**KIRKLEES METROPOLITAN COUNCIL
INVESTMENT & REGENERATION SERVICE**

DELEGATED DECISION TO DETERMINE PLANNING APPLICATIONS

Reference No:	2024/62/92303/E
Site Address:	74, Station Lane, Birkenshaw, BD11 2JE
Description:	Erection of single and two storey rear extension and detached garden room
Recommending Officer:	Edward Cheseldine

DECISION – Conditional Full Permission

4 SOUTH-WEST ELEVATION AS PROPOSED (PART)
SCALE 1:50

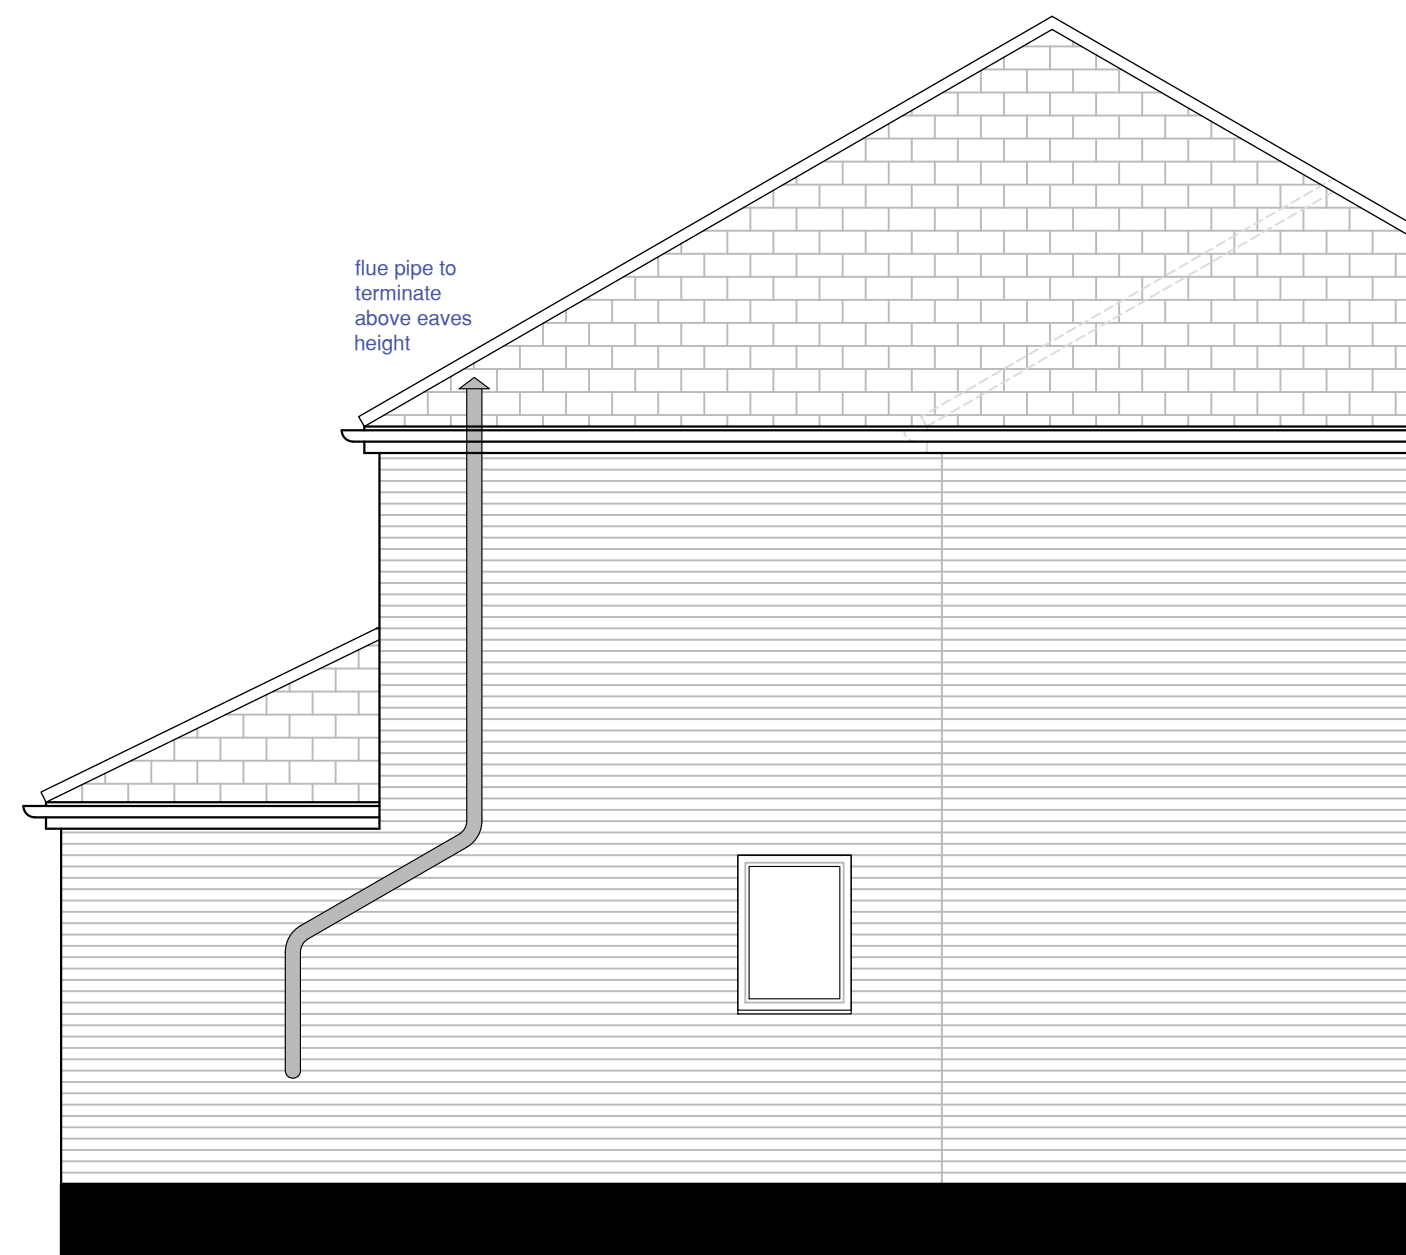
<u>Yes - COMPLY</u>	<u>No - JUSTIFY</u>
Be in keeping with the scale and style of the original house	The extension will form an 'infill' to a previous extension. In this case, the principle has therefore already been established. The additions will form a rectangular footprint with materials to match the existing dwelling which is in keeping with the original design of the property.	
Not normally cover more than half the total area around the original house (including previous extensions and outbuildings)		When including the outbuilding, the existing and proposed extensions will be greater than half the total footprint of the house. The outbuilding is visually separate from the main dwelling. The plot is a large residential area, the additions to the dwelling will provide a 'infill' extension. It is not considered that the additions would result in a negative impact to the original dwelling.

Not exceed 4 metres in height		The extension would have an eaves height of ~5.00m .it would meet the eaves of the original dwelling and is acceptable in this instance.

Relevant key design principle (KDP) of the SPD, Policy in the Kirklees Local Plan and the NPPF	Further comments	✓ / X / N/A
Impact on the Local character and street scene	• KDP1 of the SPD • Policy LP24 Design (a) and (c) of the KLP • Chapter 12 NPPF	The extensions are to the rear of the property and are respectable in scale to nearby dwellings, therefore there will be no impact to local character.	✓
Impact on original house	• KDP2 of the SPD • Policy LP24 Design (c) and (d) of the KLP • Chapter 12 of the NPPF	The rear extension will form an 'infill' extension that will complete the appearance of the dwelling. In terms of the outbuilding, the materials are modern in appearance and whilst they do not match the host dwelling, considering it is an independent structure the appearance does not contribute to a change of character to the original house.	✓
Height, scale and massing	• KDP 1 and 2 of the SPD • Policy LP24 Design (a), (c) and (d) of the KLP	The scale is relative to the existing dwelling, previous extension and plot. The height of the rear extension will match the host dwelling.	✓

Impact on privacy of neighbours (to sides, rear and front)	• KDP 3 & 4 of the SPD • Policy LP24 Design (d) (iv) • Chapter 12 of the NPPF	There will be rear facing windows on the new extension. They will have a view towards neighbouring, private outdoor space. Given the angle of outlook is indirect and the neighbouring dwelling overlooks the residential space of the application site to a degree, the relationship is acceptable. In terms of the outbuilding, it will have windows with an outlook from habitable rooms that face No. 76. There is a separation distance of 17.00m between habitable windows on the first-floor of No.76 and 13.60m from non-habitable windows. The House Extension and Alteration Supplementary Planning Document states in paragraph 4.10, <i>A minimum separation of: no less than 12 metres is recommended between windows of habitable rooms that face onto windows of a non-habitable room no less than 21 metres is recommended between facing windows of habitable rooms</i> In terms of habitable windows, the outlooks are set at an acute angle, there is a difference in floor levels, due to this,	✓

the relationship is acceptable.	
Impact on light, outlook and creating an overbearing impact to neighbours (to sides, rear and front)	• KDP 4, 5, 6 of the SPD • Policy LP24 Design (b) • Chapter 12 of the NPPF	There are side facing windows on the dwelling of No. 76, which are thought to light a W/C and a utility room. Whilst the relationship of the built form is close, the distance of separation is sufficient to allow a flow of light into the window. The side space is used as an access to the rear garden. Given the above, the development is not considered to be to the detriment of light or create an overbearing impact. The garden is currently bounded by a thick shrub border. The outbuilding is single storey in height, given this the outbuilding will not be overbearing to the neighbouring occupants.	✓
